Ms D Slade
Draycott Chartered Surveyors
82a High Street
Lymington
Hampshire
SO41 9AN

02 February 2021

Case Number EQ/20/51094
Proposal Replacement dwelling
Site Wicksmead, Penn Common Road, Bramshaw, Lyndhurst,
SO43 7JL

Project Title: WICKSMEAD, PENN COMMON BRAMSHAW. SO43 7JL		
Drawing Title: FLOOR PLANS		
Client: MR & MRS PARKS		
Scale: 1:100 @ A3	Date: SEPT 20	Drawn by: OE
Job No: W200 269	Drawing No: SK01	Rev: J

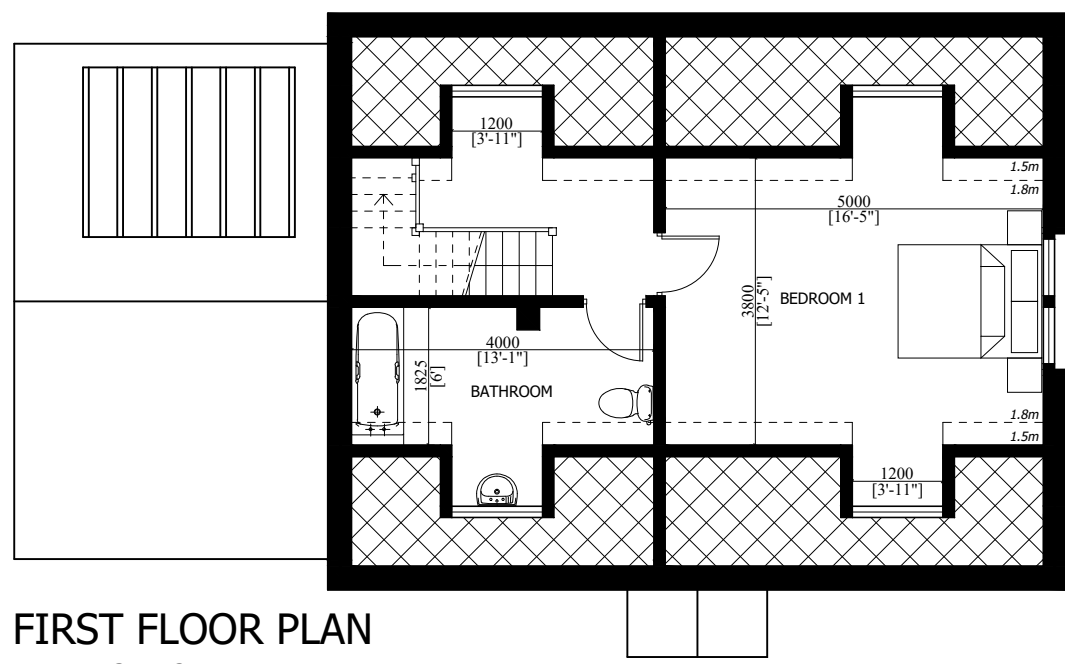
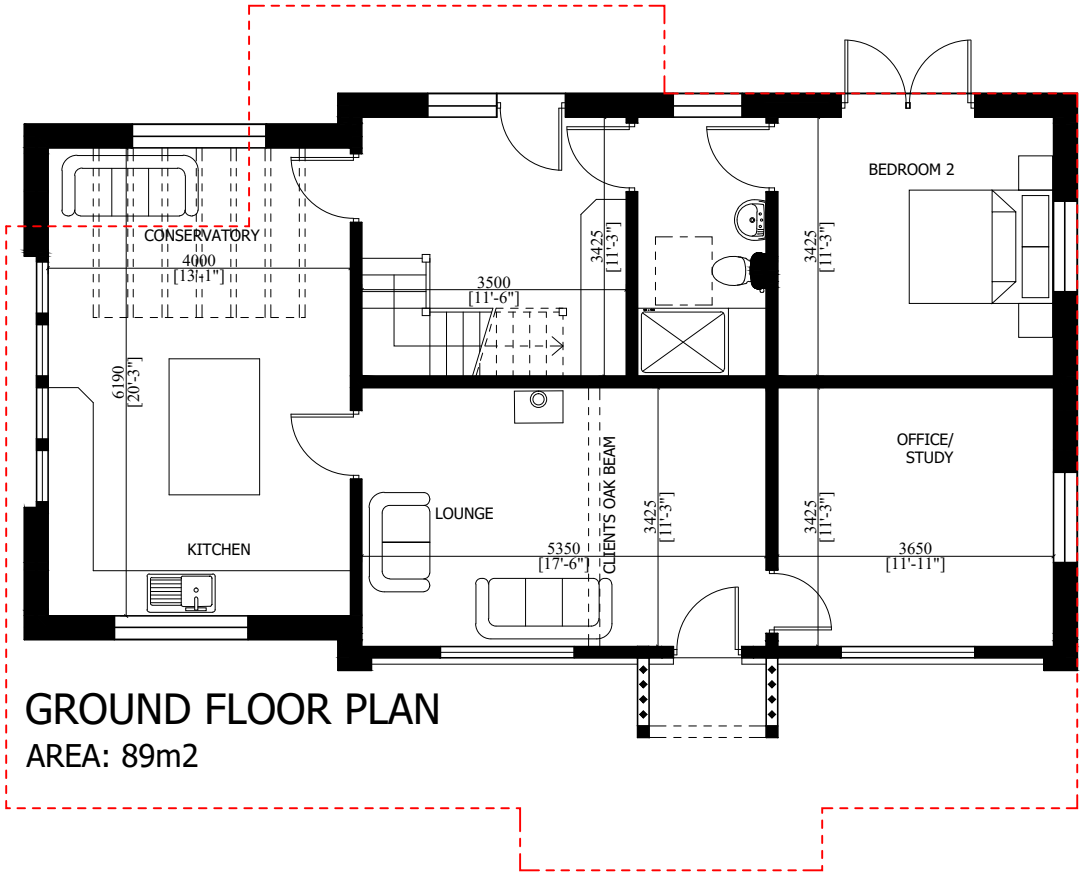
Firstly, it appears that the area of the upper floor has been measured using the dotted line on the plans. However, the section drawing shows the walls of the upper floor rooms would be 1.5 metres, and therefore the entire first floor would be habitable floor space. The proposed upper floor would be larger in area than the 34 square metres stated.

ensure it is not altered and remains within the definition of a conservatory, as set out in the Local Plan. If your client wishes to take advantage of the extra 13.5 square metres that has been granted as a conservatory, the design of the replacement should include at least that much floor area within a conservatory.

With regard to the proposed replacement dwelling, the proposal appears to be of a similar footprint, scale and size, and subject to the above amendments would be likely to be acceptable. However, the inclusion of a conservatory will necessitate some redesign.

Project Title: WICKSMEAD, PENN COMMON BRAMSHAW. SO43 7JL		
Drawing Title: EXISTING PLANS & ELEVATIONS		
Client: MR & MRS PARKS		
Scale: 1:100 @ A3	Date: SEPT 20	Drawn by: OE
Job No: W200 269	Drawing No: SK06	Rev: J

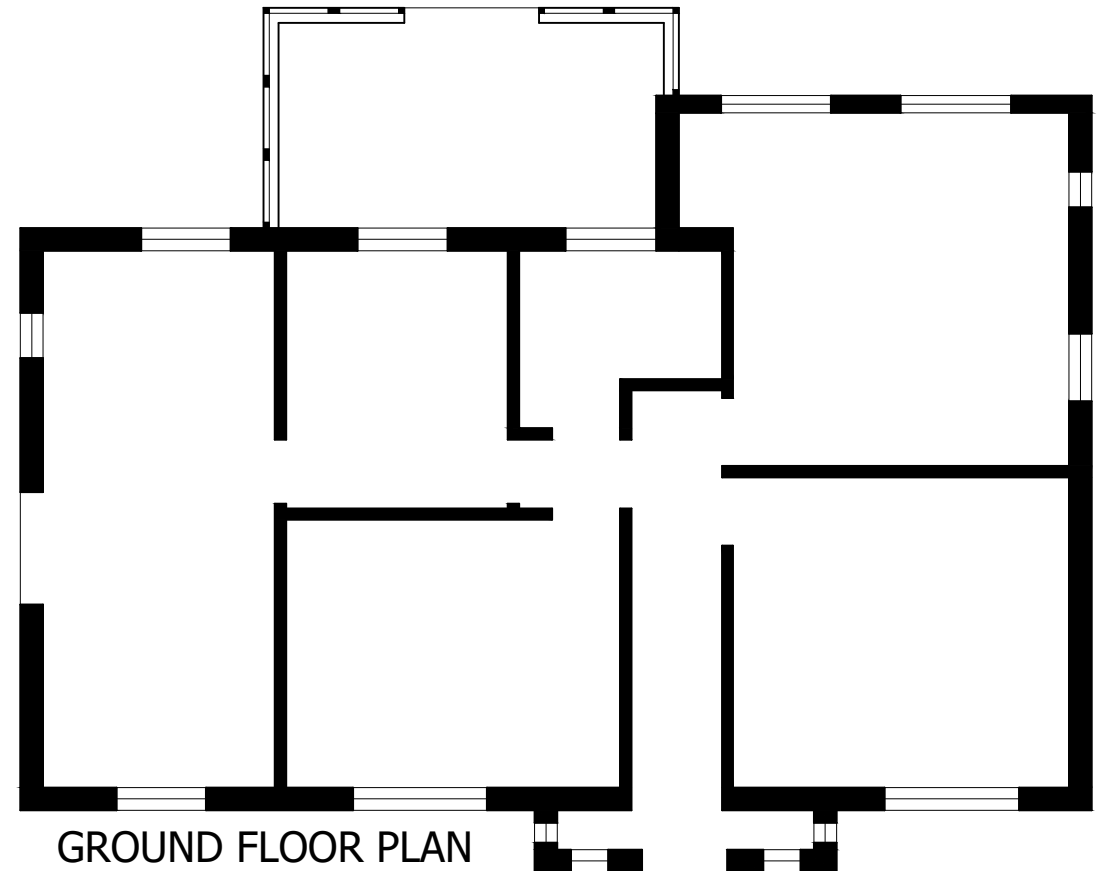
The property is a small dwelling as defined in Policy DP36 of the Local Plan as the history shows its floor area was 76 square metres in 1982. It has been extended since the base date for the small dwellings policy and now has a floor area of 123 square metres, according to your plans, which is in excess of the normal limits for a small dwelling.

The history shows a conservatory was added to the property, following consent in 2005 using the 'conservatories exemption', which allowed a conservatory as an exception to the floor area limits. I calculate that the approved conservatory that was permitted had an internal floor area of 13.5 square metres.
